Rezoning Transportation Analysis

Petition Number: 2021-092

From: Lakisha Hull, AICP, LEED AP BD+C

Date	Description
06-01-2021	First Review (KP)
08-23-2021	Second Review (KP)
10-22-2021	Third Review (KP)

TYPICAL SECTIONS

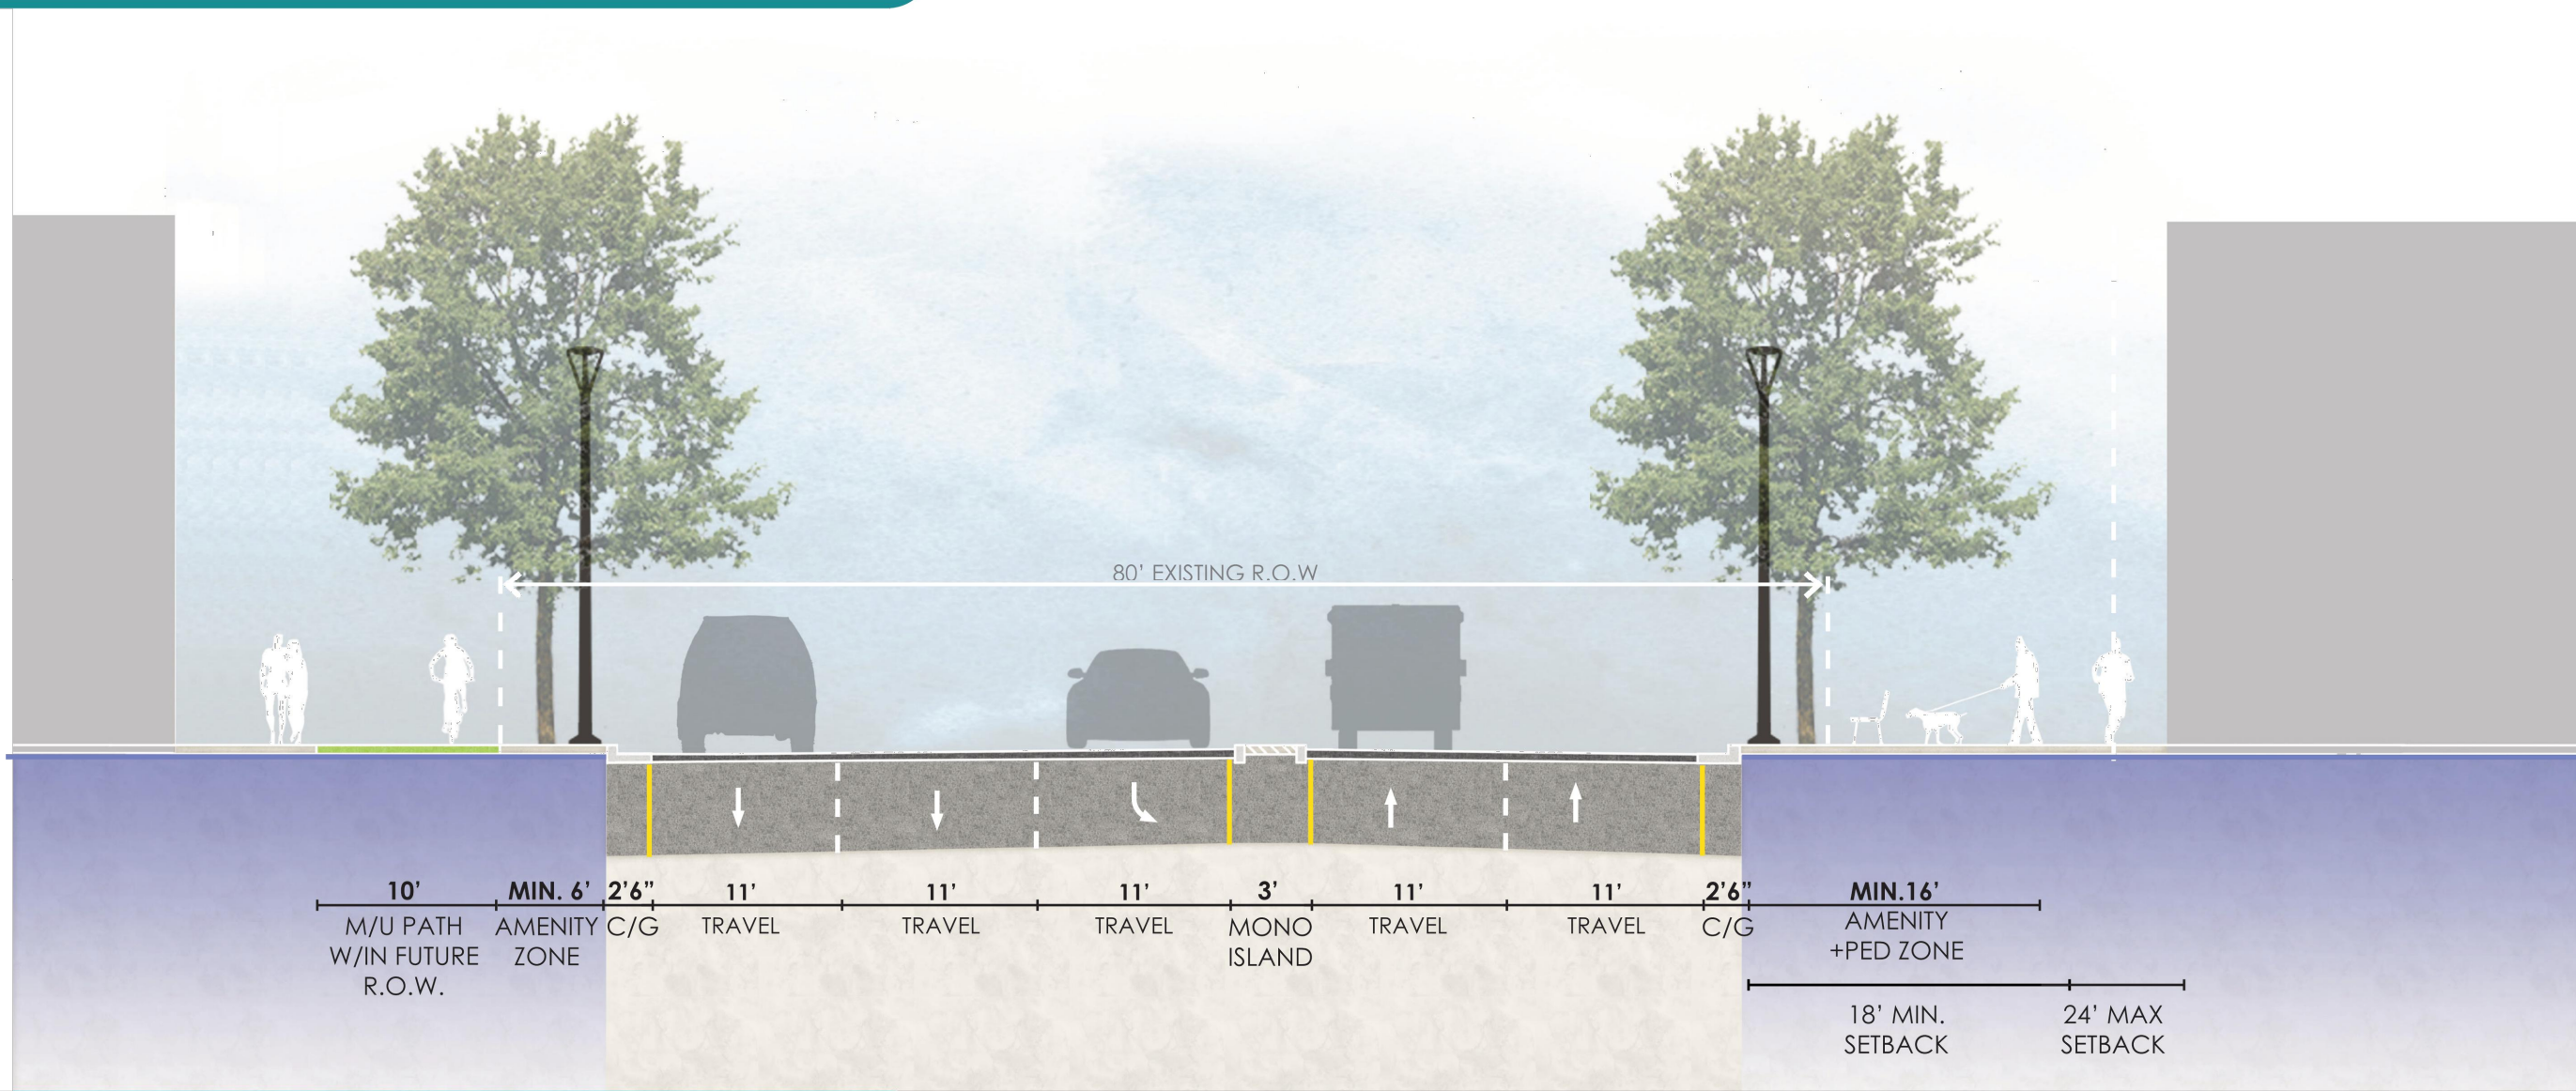
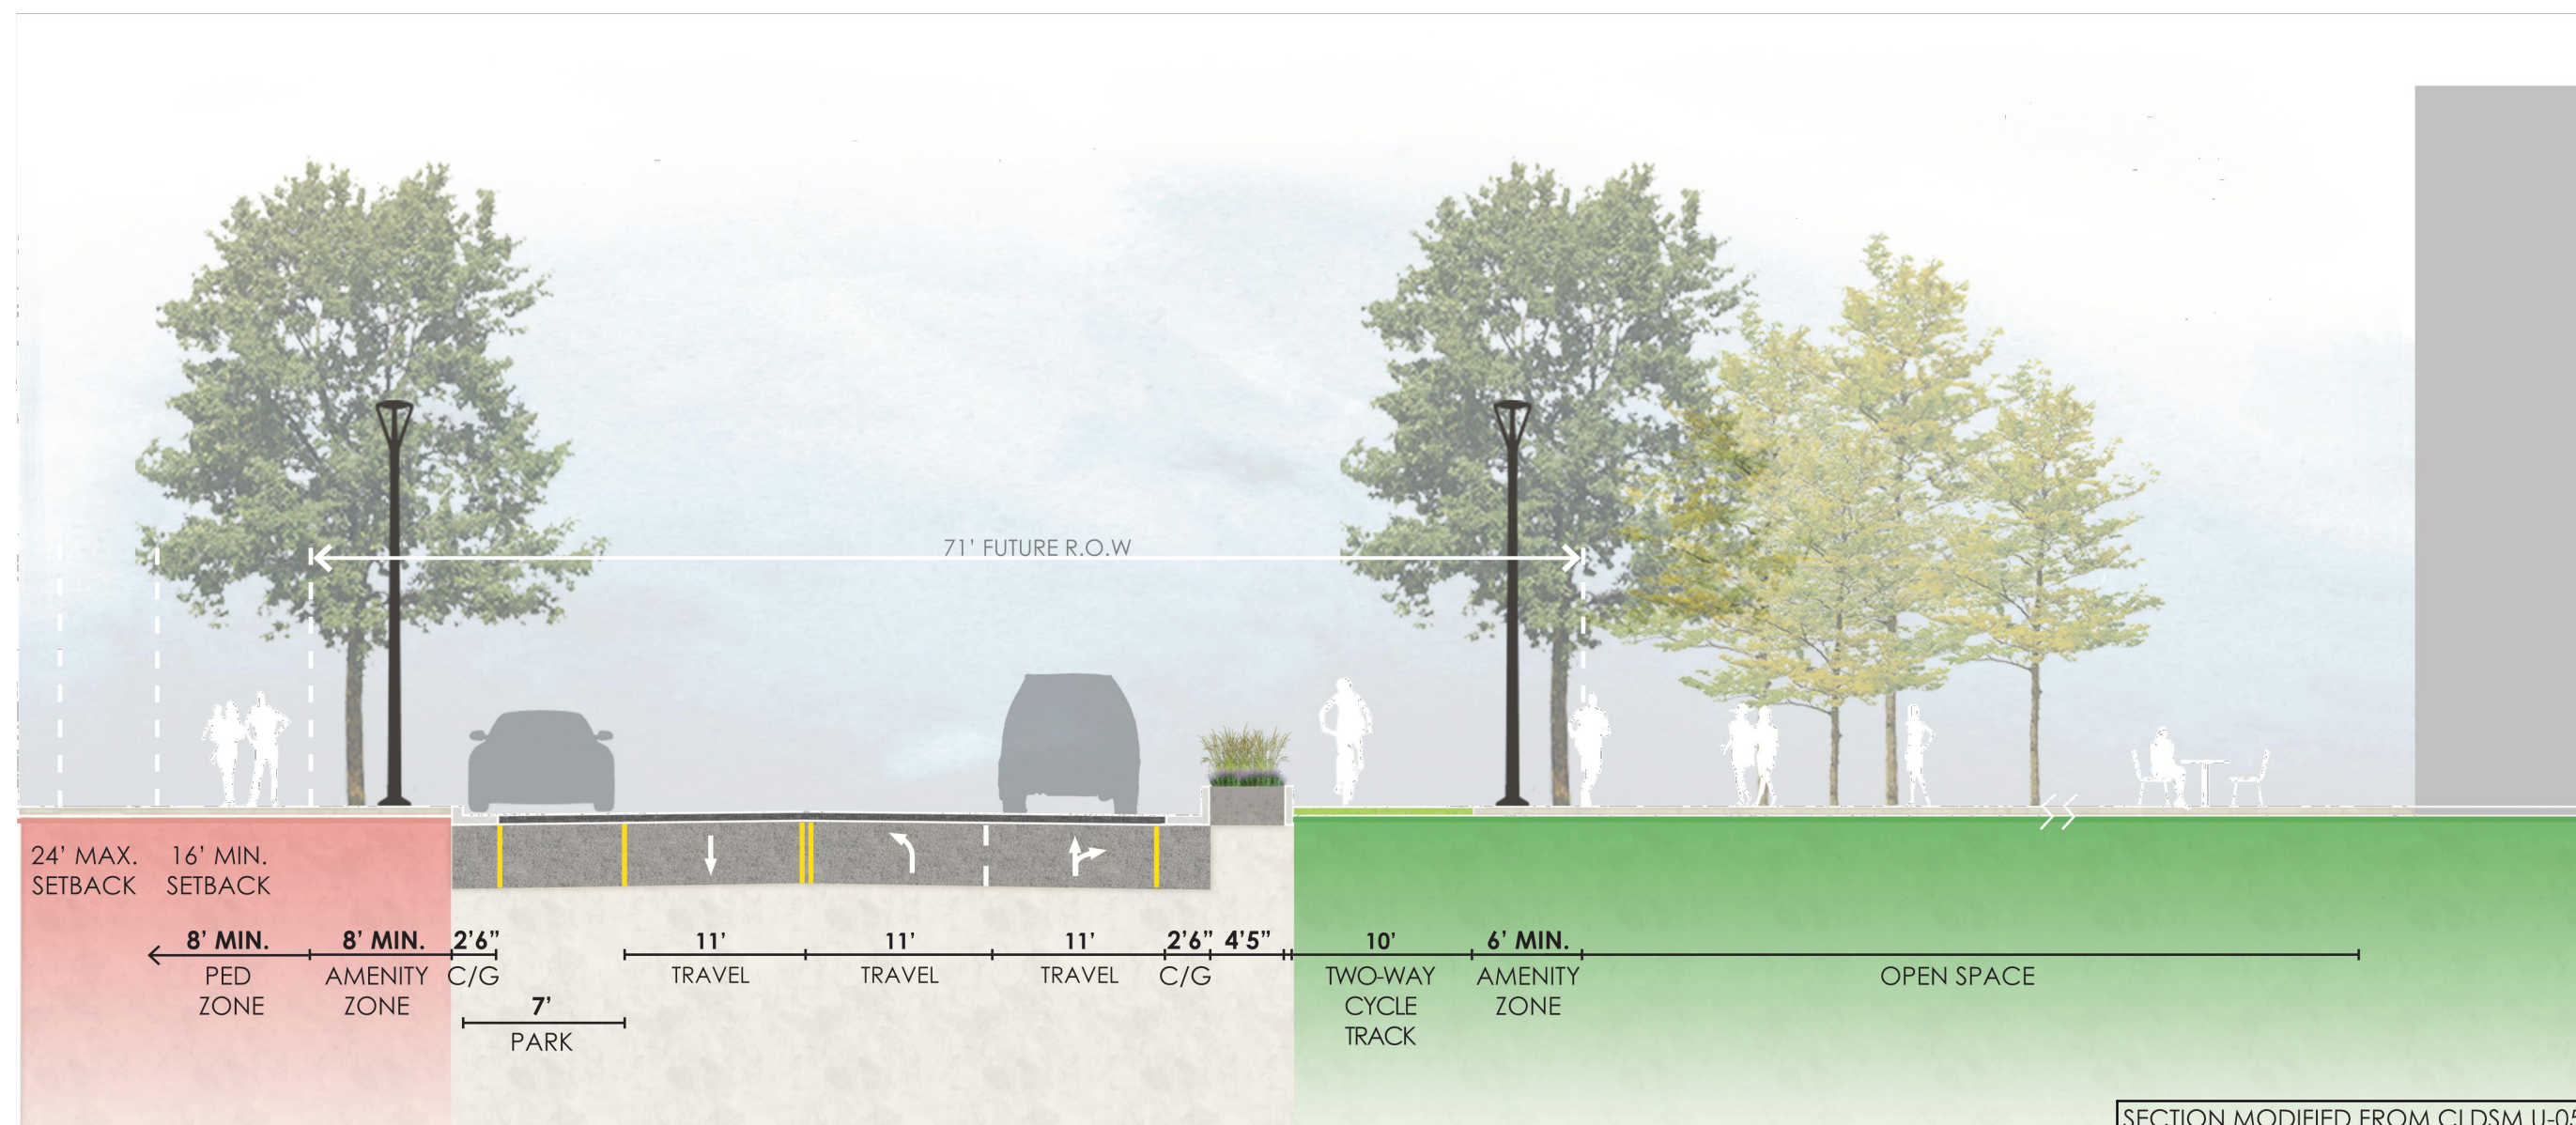
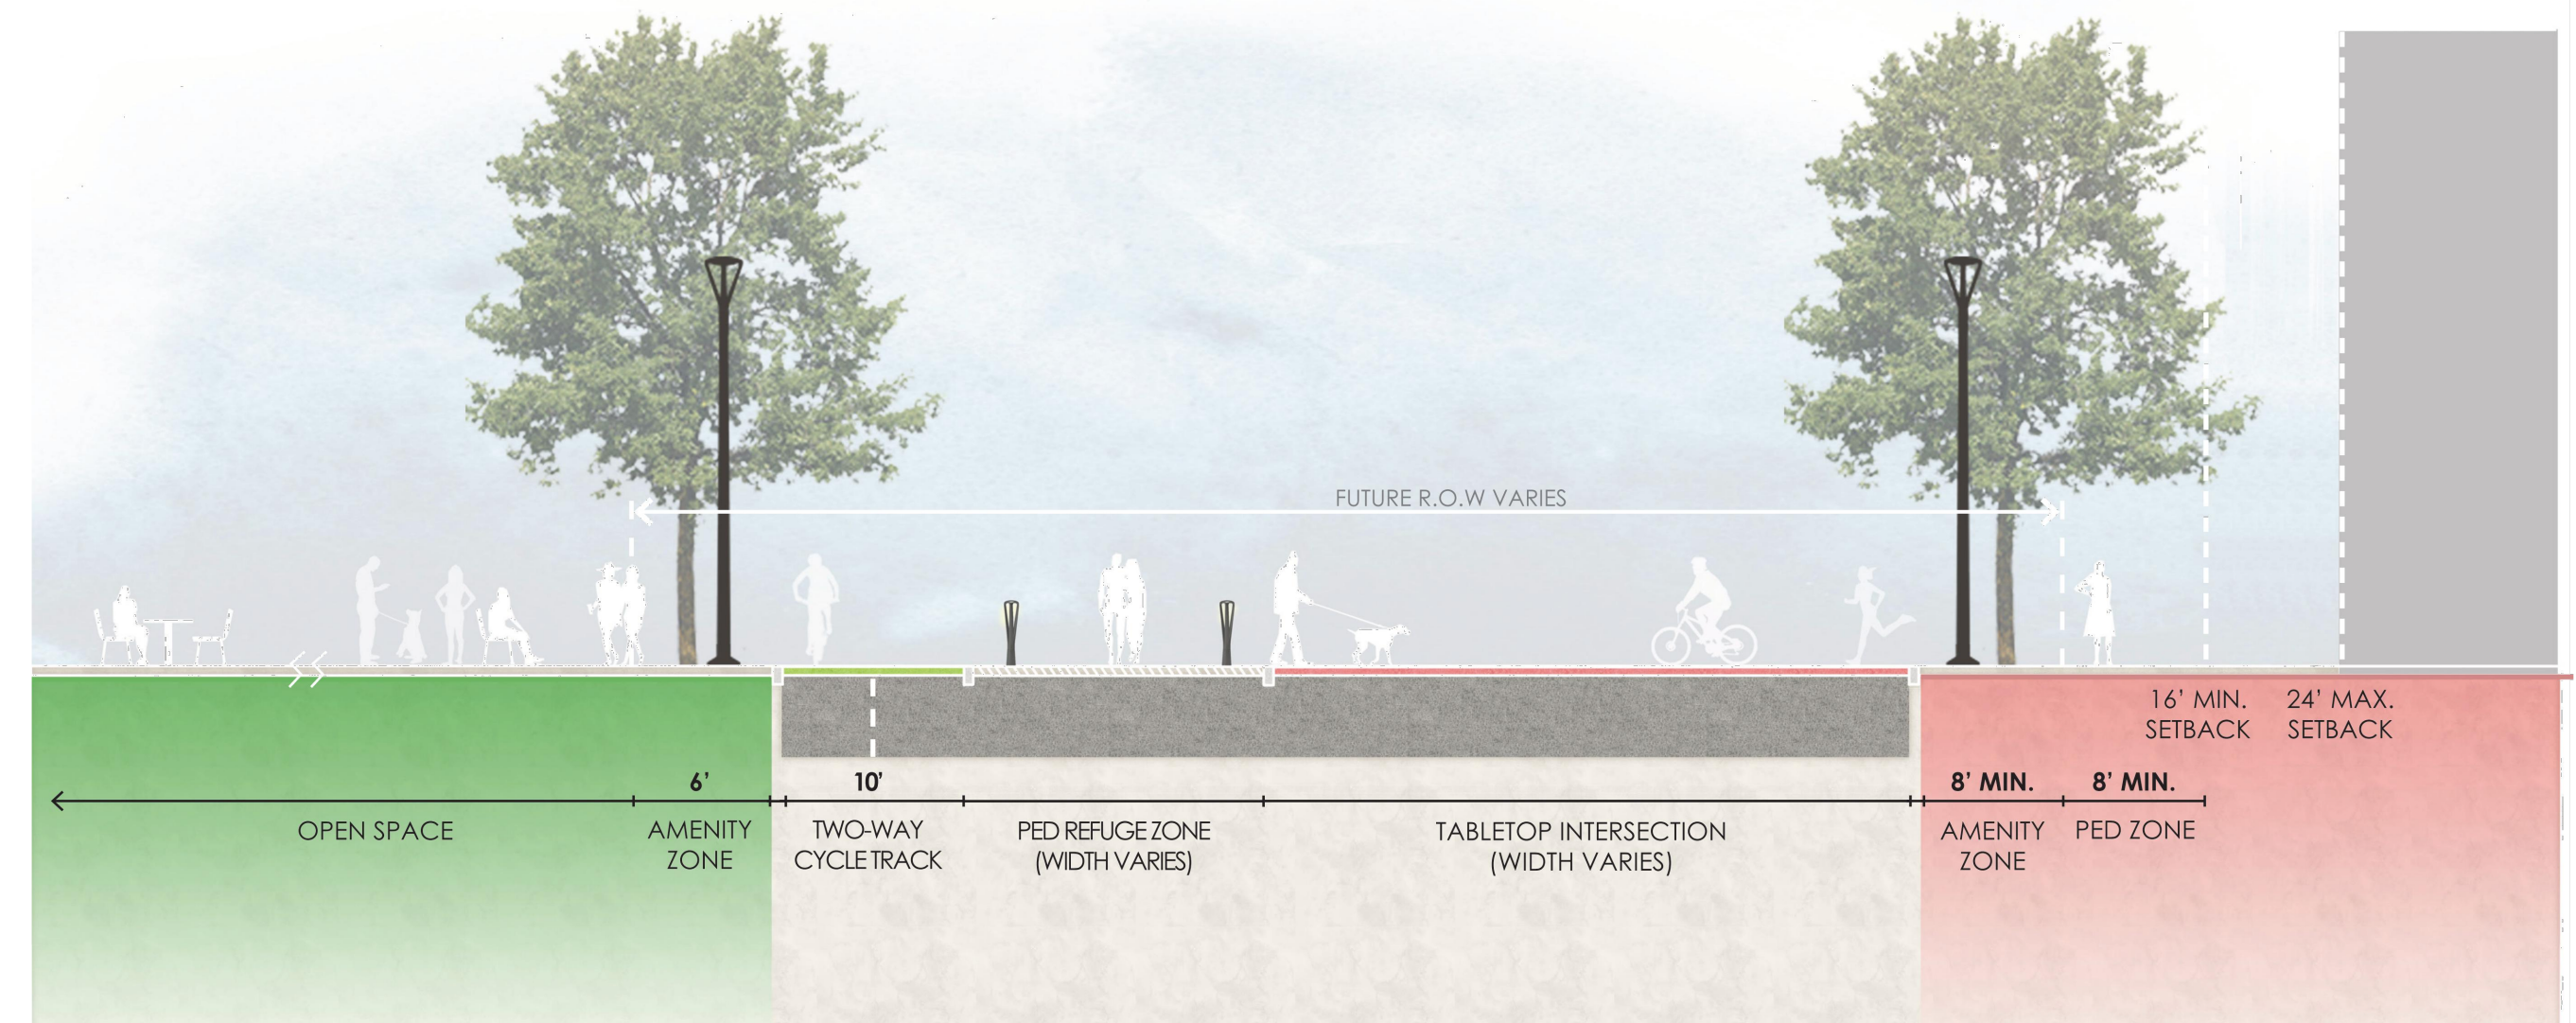
4. ~~Revise the Rezoning Sheet RZ-1.0 and RZ-1.1 by establishing a cross section associated with the proposed private street connecting McDowell Street to Baxter Street Extension. Include the cross section on Rezoning Sheet RZ-1.1.~~
